DELEGATED DECISION TO DETERMINE APPLICATIONS FOR LISTED BUILDING CONSENT

Reference No:	2022/65/91433/W
Site Address:	15, Edgerton Road, Huddersfield, HD3 3AA
Description:	Listed Building Consent for replacement windows and door (within a Conservation Area)
Recommending Officer:	Sebastian Pickles

DECISION – Listed Building Consent Refused

Horizontal section through top sash

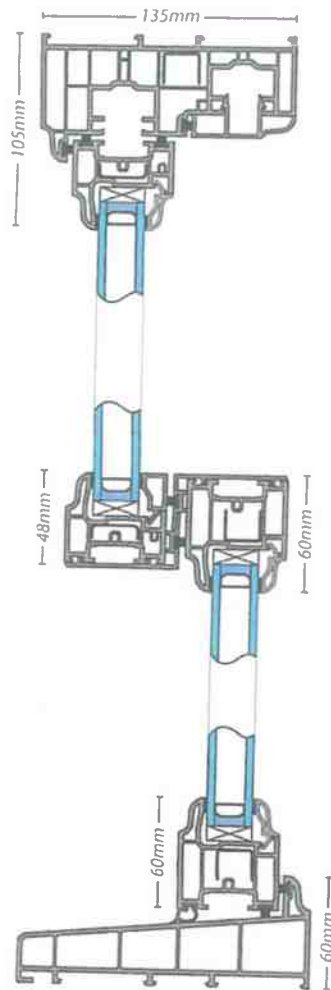
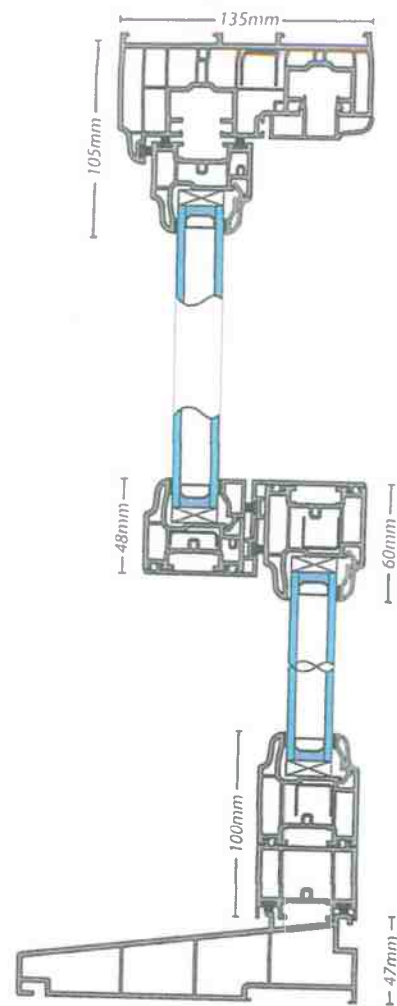
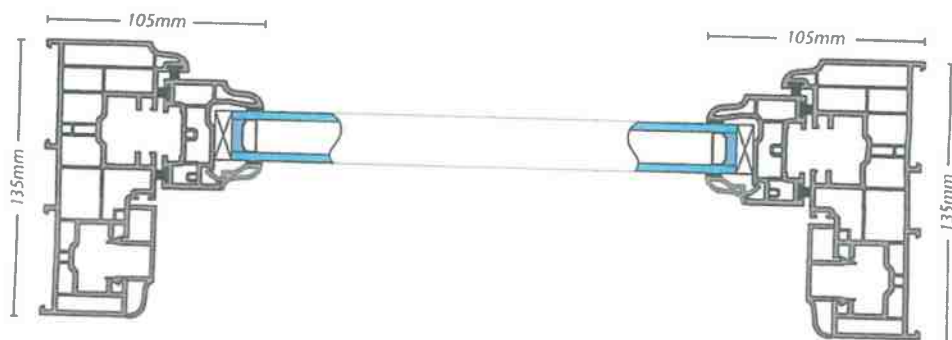
The Heritage Statement states that the proposal is to replace the existing windows with off white uPVC sash windows. The existing leaded light windows are to remain intact. There is no detail provided to show that the existing windows are beyond economical repair and heritage statement sets out the existing windows are in fair condition. It further states that the existing are thin single glazed and do not fit properly allowing air through gaps allowing heat loss. The application has not demonstrated that the repair of the existing windows has been considered or justified their replacement with the proposed types. The loss of the existing windows, which are considered of merit and contribute the character and significance of the Listed building would have a harmful and negative impact to the Listed Building and Conservation Area.

The applicant has failed to demonstrate that the proposed works are wholly necessary and has not demonstrated public benefits which outweigh the less than substantial harm caused to the listed building through the replacement of the historic existing timber windows and door with UPVC frames. The proposal fails to comply with paragraph 202 of the National Planning Policy Framework which requires less than substantial harm to the significance of a designated heritage asset to be weighed against the public benefits of the proposal including, where appropriate, securing its optimum viable use. The replacement of the windows will not preserve the building or features of architectural and historic interest which it possesses, as required by Section 16(2) of the Planning (Listed Buildings and Conservation Areas) Act and Policy LP35 of the Kirklees Local Plan.

drawing no.1K/2905/2 Scale 1:100

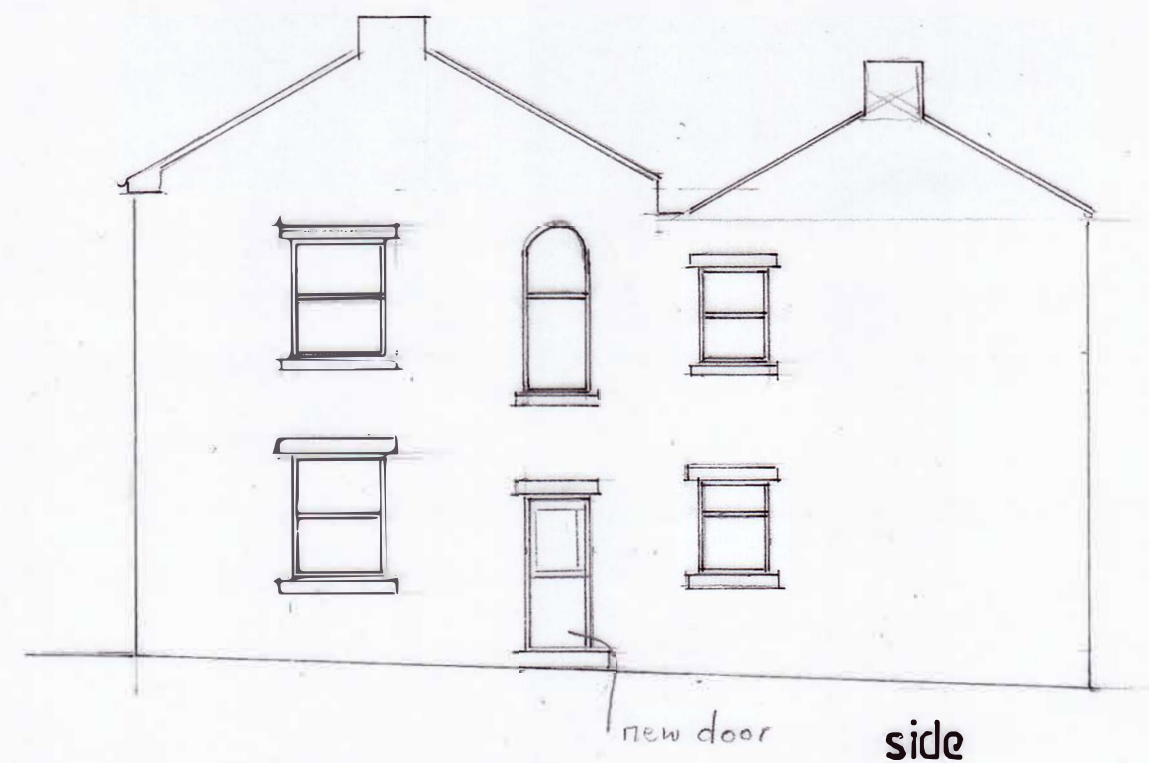
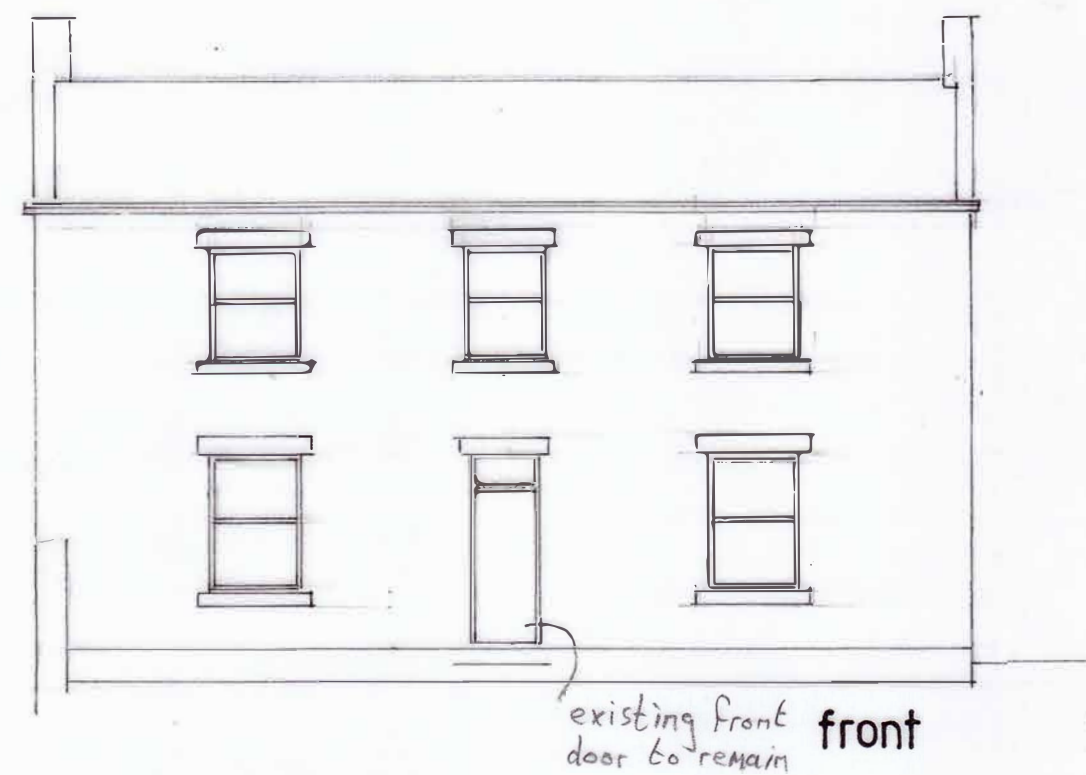
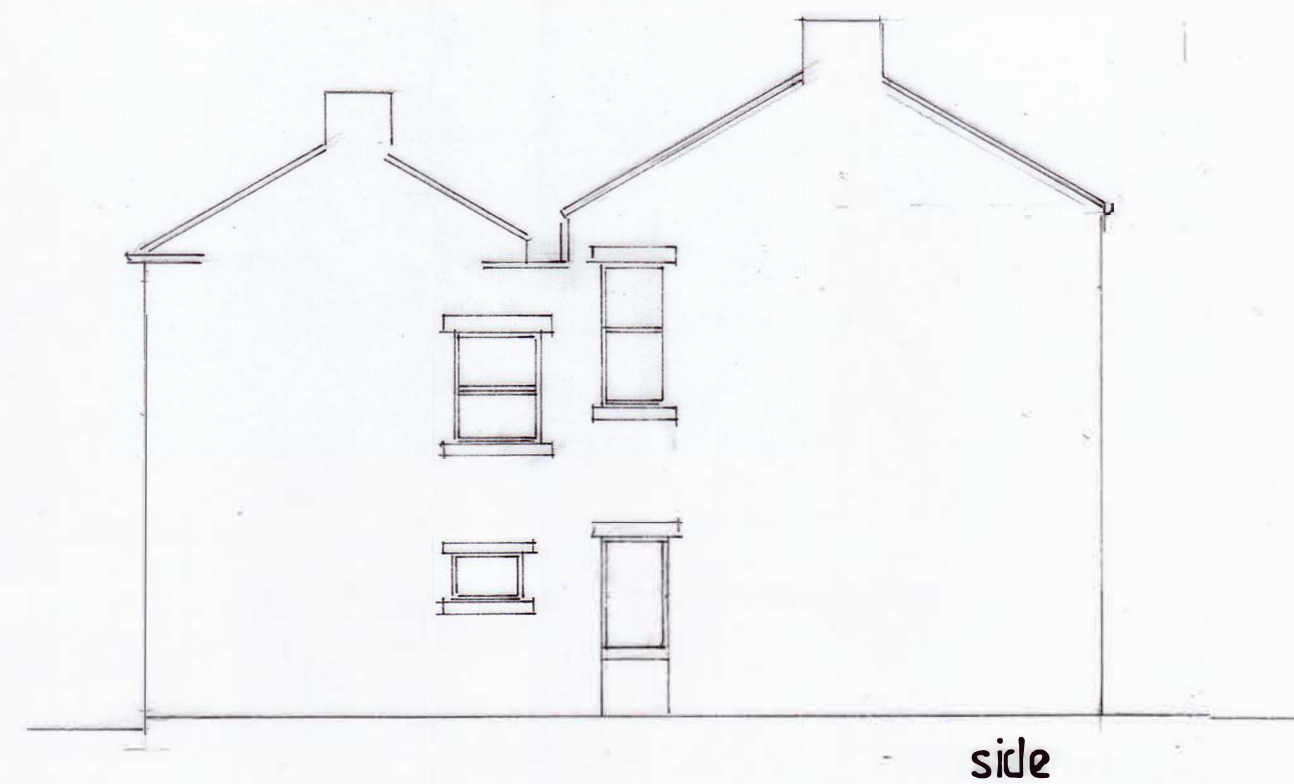
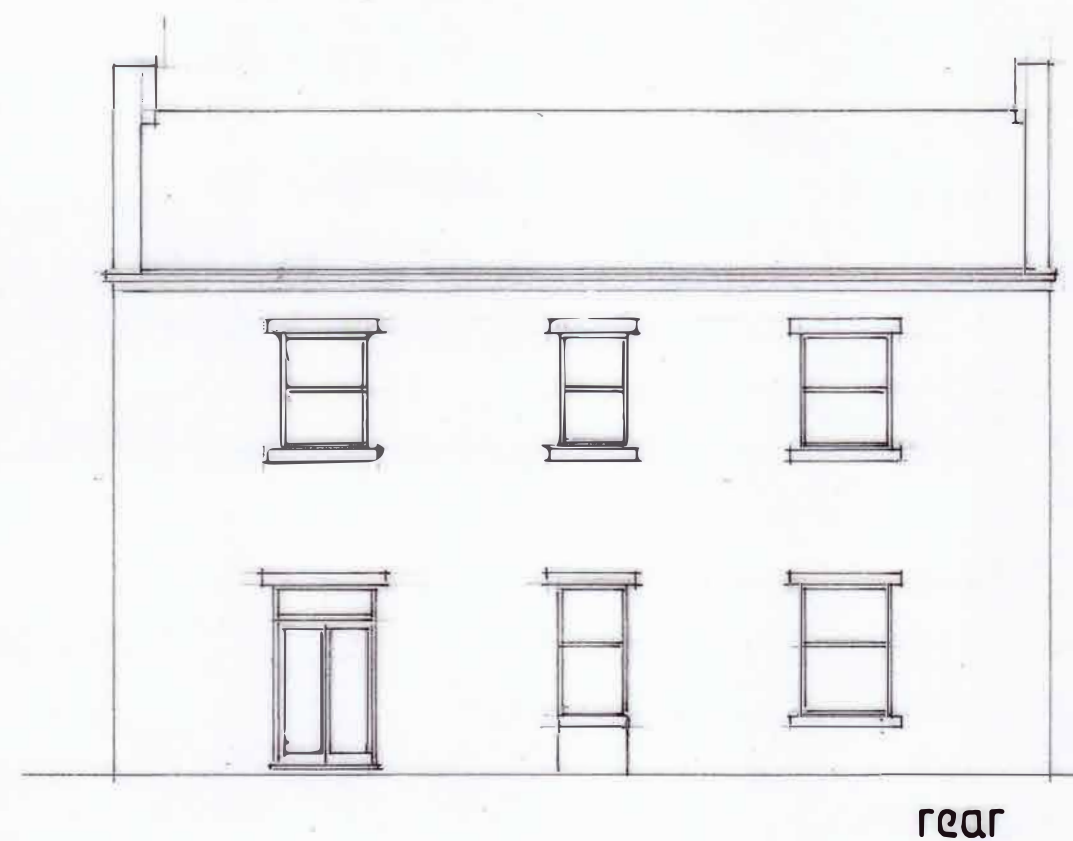
The applicant proposes the replacement of the existing timber windows and rear door with UPVC frames.

No. 15 Edgerton Road, Listed at Grade II is a large, detached dwelling. The windows are mainly of a 1 over 1 sliding sashes with some historic float glass. There are some fixed lights to the northern elevation which includes a decorative stained-glass window with lead canes. The stain glass window while being a fixed light does form a part of character of the building. To the southern elevation there is one casement stile window and in central first floor is an elongated curved head landing window. The existing windows are single glazed and many of the windows do include historic float glass, which is evident from the uneven and ripple finish to the glazing. Most of the existing windows are considered to be of historic merit and significance to the building and the loss of the windows

The proposal to replace the existing historic windows with modern replacements does not preserve or enhance the character and appearance of the conservation area.

The loss of the existing historic windows and replacement with a modern alternative, will harm the significance of the listed building and erode its architectural interest. It will also harm the character of this part of the conservation area, which is characterised by large, well-designed villas with bespoke detailing.
